From: Laura Bell
 To: DC Support
 Subject: FW: 22836 RE: 5018932 - Oxford United FC - New Stadium Development - Planning Ref: 24/00539/F
 Date: 19 June 2024 10:14:31
 Attachments: image001.png
 image002.png
 image003.png
 image004.png
 image005.png
 image006.png
 image007.png
 image008.png
 image009.png
 image010.png
 image011.png
 image012.png

From: Patrick Blake <Patrick.Blake@nationalhighways.co.uk>
 Sent: Wednesday, June 12, 2024 5:04 PM
 To: Dave Cope <davecope@ridge.co.uk>
 Cc: Sarah Matthews <sarahmatthews@ridge.co.uk>; Paul Robertson <paulrobertson@ridge.co.uk>; Tom Ravenhall <tomravenhall@ridge.co.uk>; Giles Brockbank <GBrockbank@ridge.co.uk>; Planning SE <planningse@nationalhighways.co.uk>; Beata Ginn <Beata.Ginn@nationalhighways.co.uk>; Doyle, Simon/LON <Simon.Doyle@jacobs.com>; Colclough, Joseph <Joseph.Colclough@jacobs.com>; Laura Bell <Laura.Bell@Cherwell-DC.gov.uk>; Beata Ginn <Beata.Ginn@nationalhighways.co.uk>
 Subject: RE: 22836 RE: 5018932 - Oxford United FC - New Stadium Development - Planning Ref: 24/00539/F

Table 1: JSJV's Review of 'Oxford United Football Club – New Stadium Development, Transport Assessment' (February 2024), 'Oxford United Football Club – N

Figure 4.1: OUFC VISSIM Model Extents

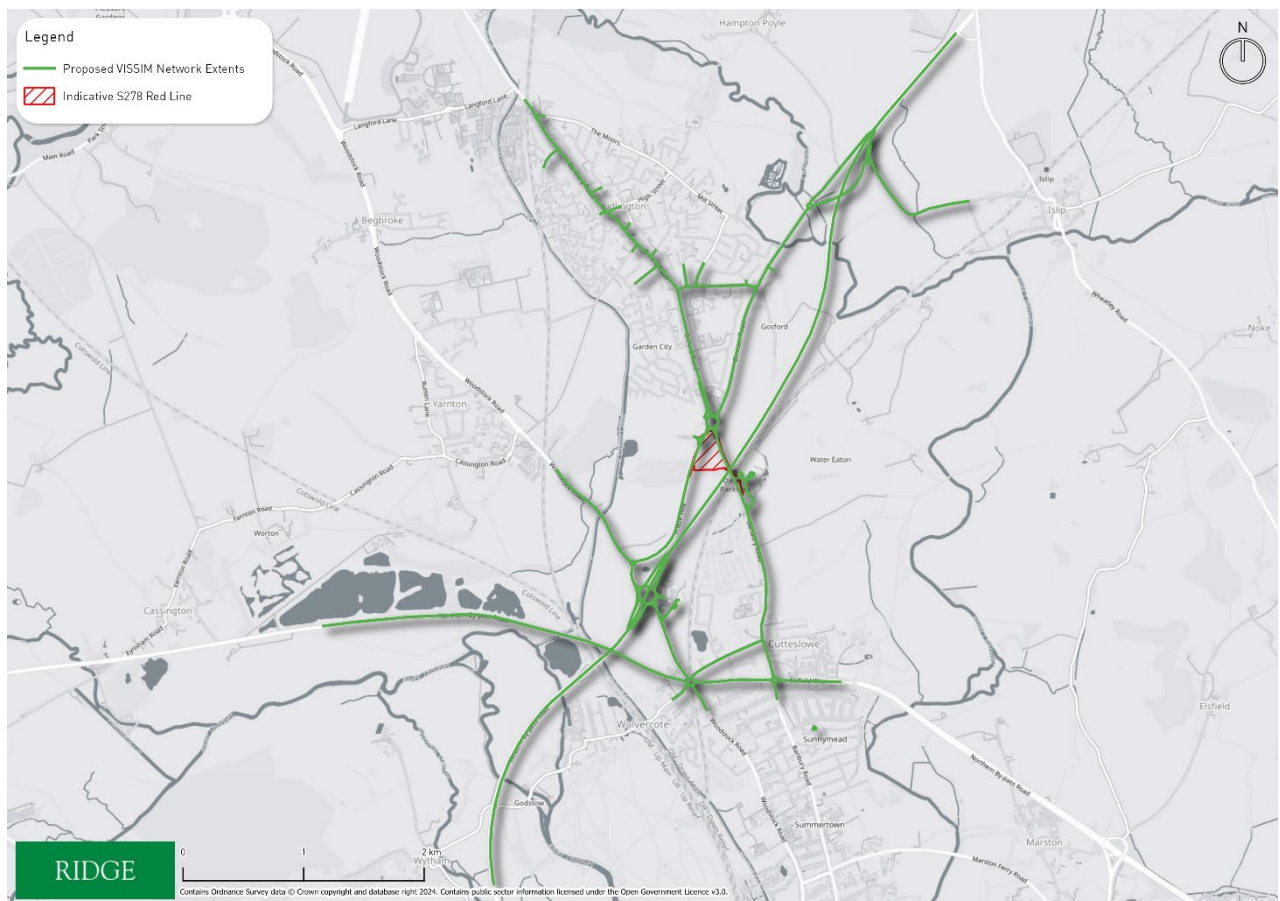
• 2 LinSig Weekday Conference scenario models			
		Table 2.1	NA	4	An additional column representing the '2018 BASE YEAR' models should be added to Table 2.1 for clarity.
				5	What junctions or extent of highway network will the LinSig models cover?
VISSIM modelling	4	4.1.3 & Figure 4.1	The highway network will be amended, this will include the cordoning of the existing network to the extents shown in Figure 4.1.	6	The model cordoning (and extension) proposal appears reasonable. However, the amounts of traffic not loading onto the VISSIM network should be monitored and tracked if queue lengths exceed available highway queue storage.
